**RFI**

RFI #: 73  
Date: 3/12/2012  
Job: EB-02 Keller Springs Lofts  
Phone: 877-777-5115

Subject: Proper location of gas meter

Drawing: C10 P-3.1C  
Cost Impact: None

**WATER AND WASTEWATER
 PLAN - PROFILE**

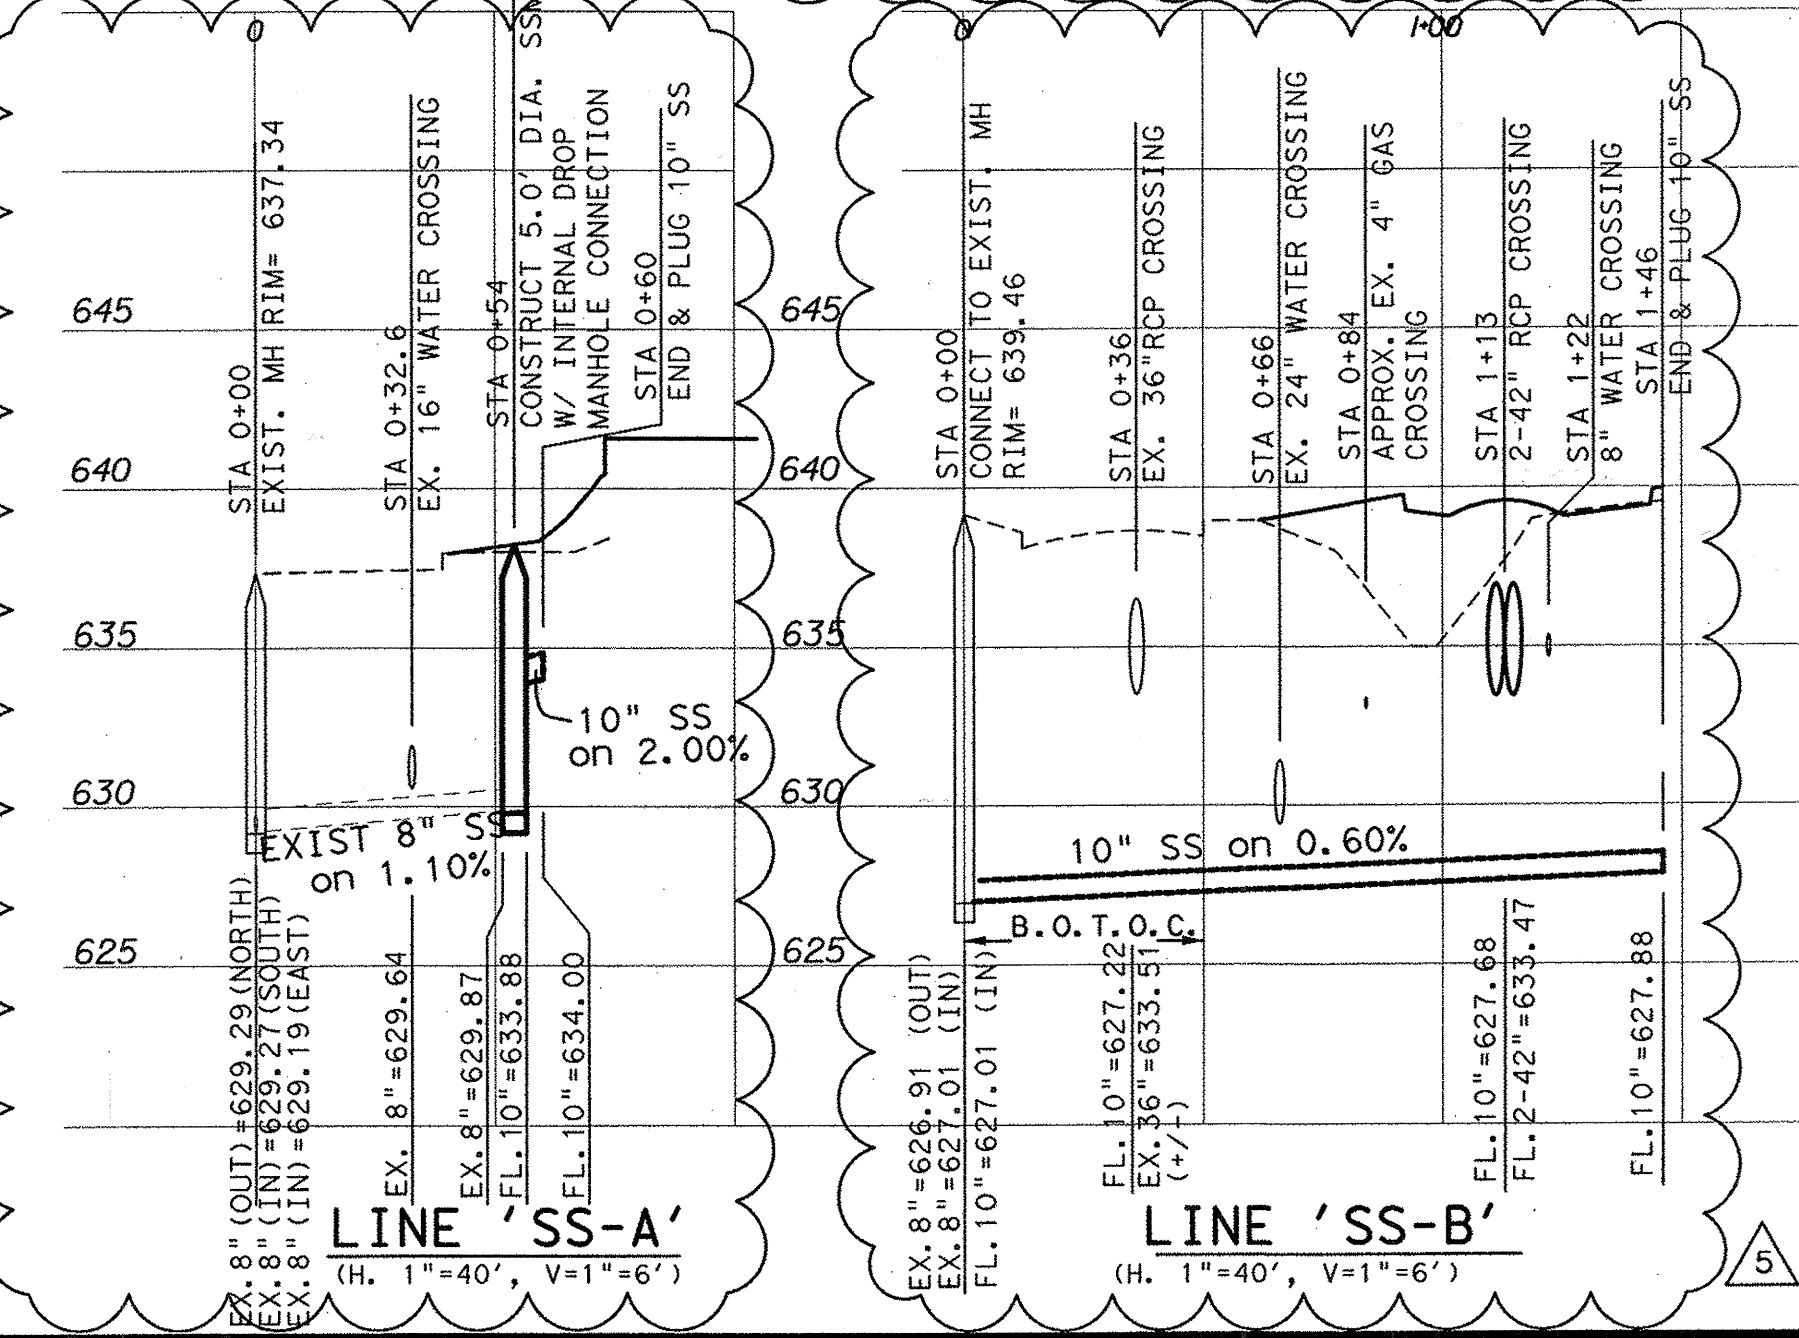
**Request:**  
The location for the gas meter appears to have changed from its original location reflected on C 10 on the Civil Plans. The new location appears on the Jordan Skala SK-P1 dated 01-19-2012. It is on a completely different part of the building from C 10 and slightly different than P-3.1C. Attached is SK # 1 which is where it's located on C 10. SK # 2 reflects where I feel it is intended to be located. SK-P1 is the revised sketch by Jordan Skala locating it where we believe it is supposed to go. I need confirmation that it does go the way I show it on SK #2 and as shown on SK-P1.  
Like I said, I need the surveyors to stake the proper location tomorrow.

**Response:**  
The gas meter should be located in the spots shown on SK#2 and SK-P1.
